Beacon Fen Energy Park – Development Consent Order

Application Reference: **EN010151**

Document: Deadline 8 – Closing Summary Statement (LCJM)

Author: Matthew Mountain, Director, L.C.J. Mountain Farms Ltd

FIGURE 7.3
LOCAL WILDLIFE SITES WITHIN 2 KM
SHEET 3 OF 5

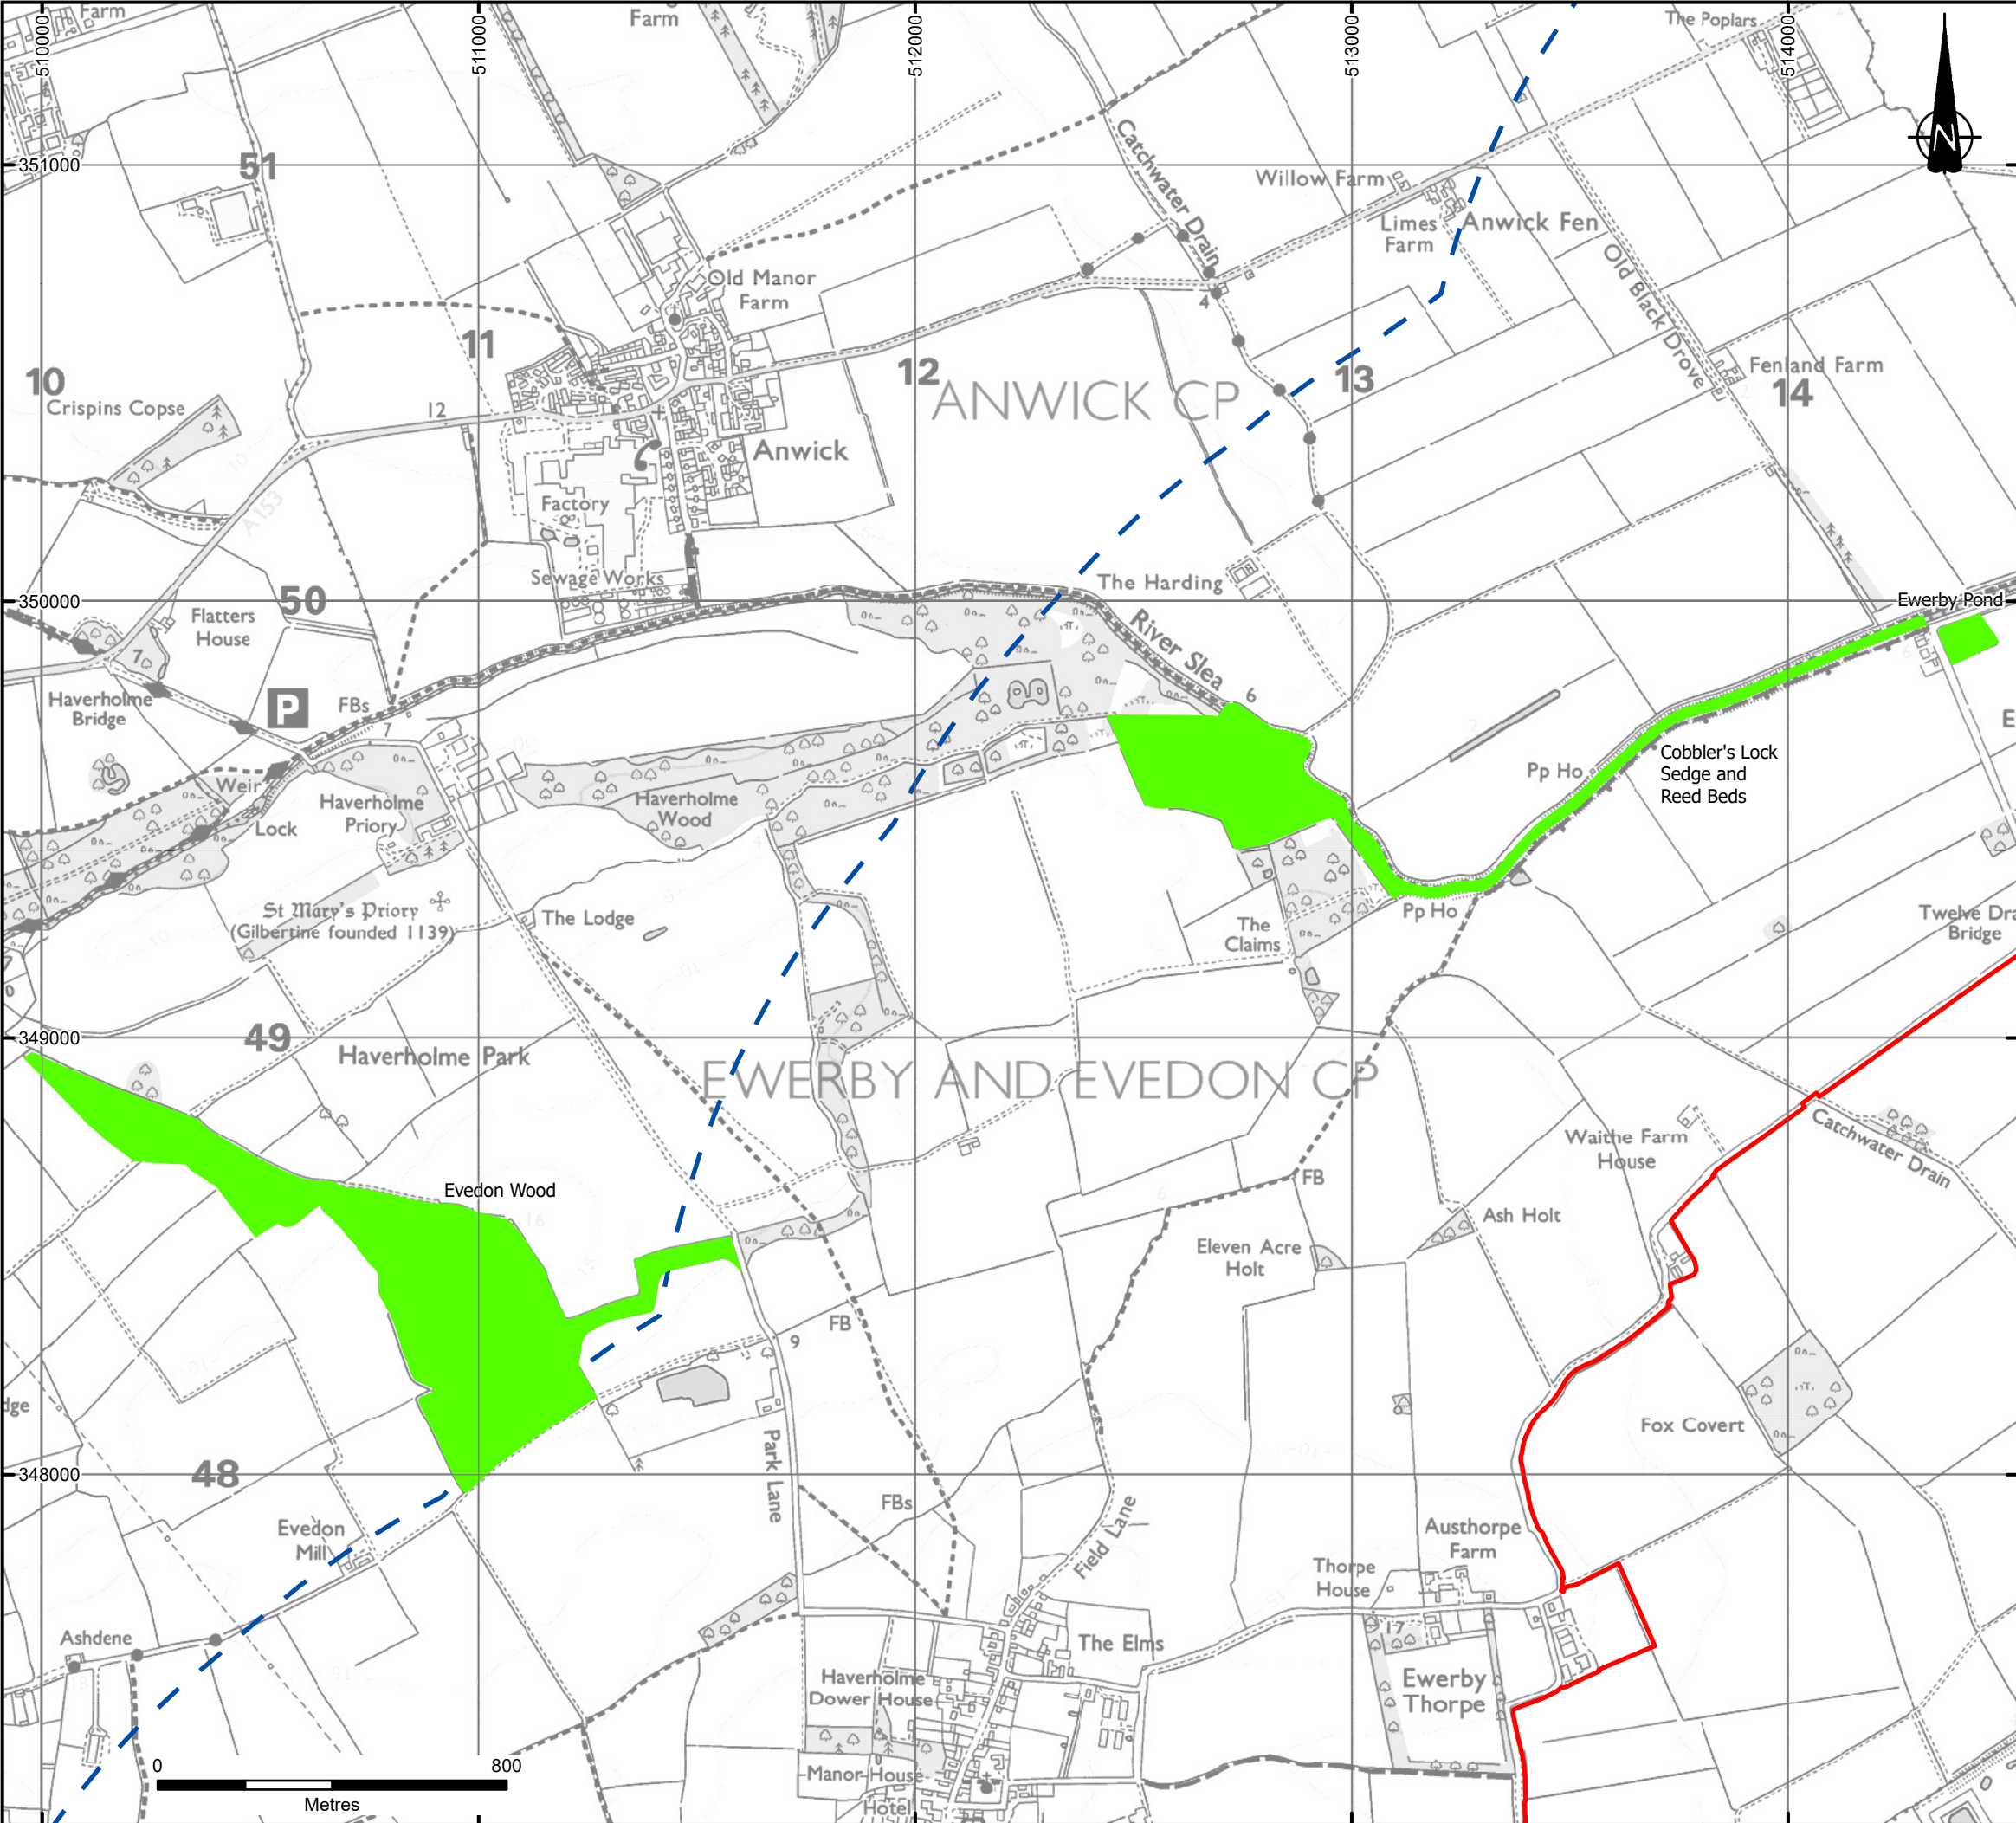
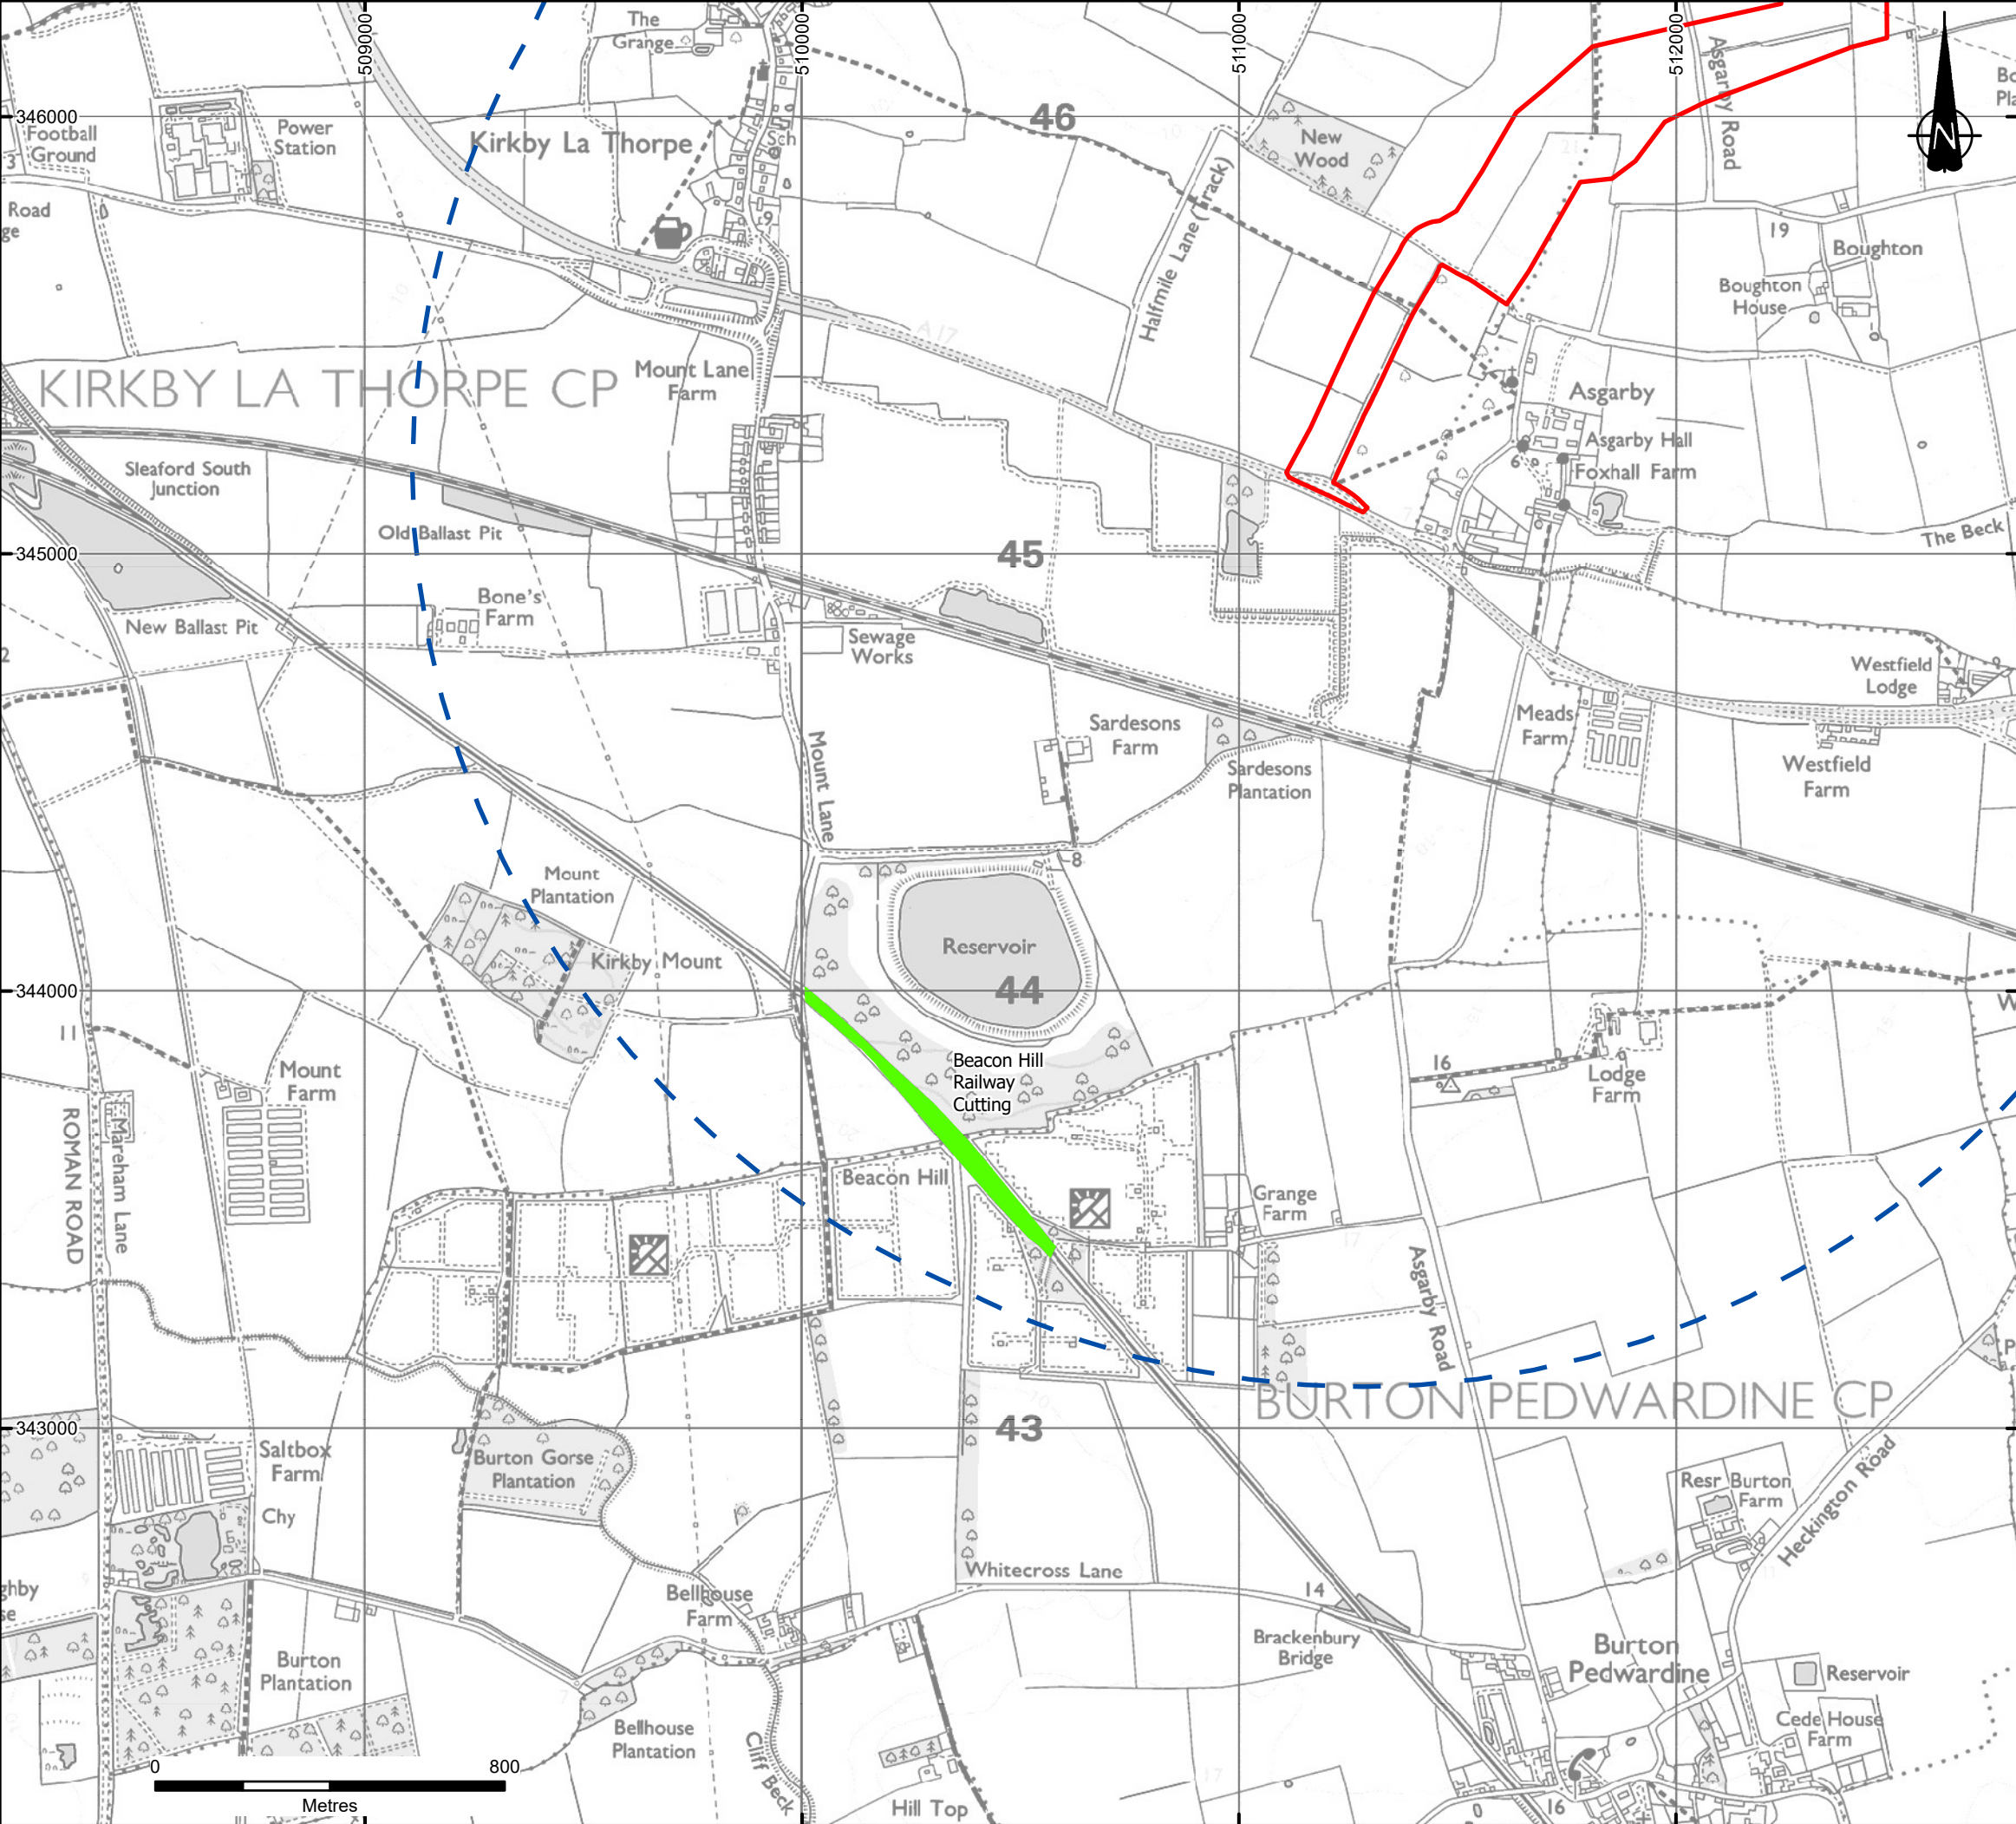
LCJM's case is that the Applicant treats LWS proximity/interaction as a discriminator against "alternatives" yet accepts substantial longitudinal interaction [1,650 metres] and "double occupation" adjacent to LWS 4722 on the chosen corridor, while simultaneously presenting temporary access as benign.

5.4a LCJM also records the decisive point for weight: the LCJM Hybrid alignment **avoids 1,650 metres occupation of LWS 4722 entirely** (i.e. it does not intersect that LWS and does not require longitudinal working alongside it). This matters because the Applicant’s own optioneering narrative treats proximity to “sensitive receptors including Local Wildlife Sites” as a discriminator against alternatives, yet the chosen corridor accepts prolonged, longitudinal interaction and indicative “double occupation” adjacent to LWS 4722. LCJM invites the ExA to record that this is not a decision-safe use of a constraint: **LWS sensitivity cannot be relied upon to rule out alternatives while being treated as acceptable-by-assumption on the selected corridor.** On that basis, LCJM invites the ExA to place reduced weight on the Applicant’s LWS-based comparative conclusions unless and until the Applicant provides an auditable, like-for-like construction footprint (including haul/access) and enforceable controls that prevent corridor creep and longitudinal working effects.

5.5 LCJM also records that the LCJM Hybrid alignment on the Little Hale Drove section has meaningful stand-off from nearby LWS features and does not intersect those LWS designations. LCJM has previously recorded on the Examination record that LWS 4489 (Mill Drain) lies approximately 274m south of the relevant section and LWS 4520 (Willow Farm Drain) lies approximately 177m north. LCJM maintains that it is not decision-safe to discount an alternative on the basis of LWS proximity while, for the chosen corridor, treating substantial longitudinal working / “double occupation” adjacent to an LWS receptor (LWS 4722) as acceptable by assumption. LCJM further notes the cumulative construction context at this location arising from the relatively recent Viking Link onshore works, which reinforces why LWS-related comparisons should be based on mapped, like-for-like construction footprints and duration assumptions rather than corridor-only screening.
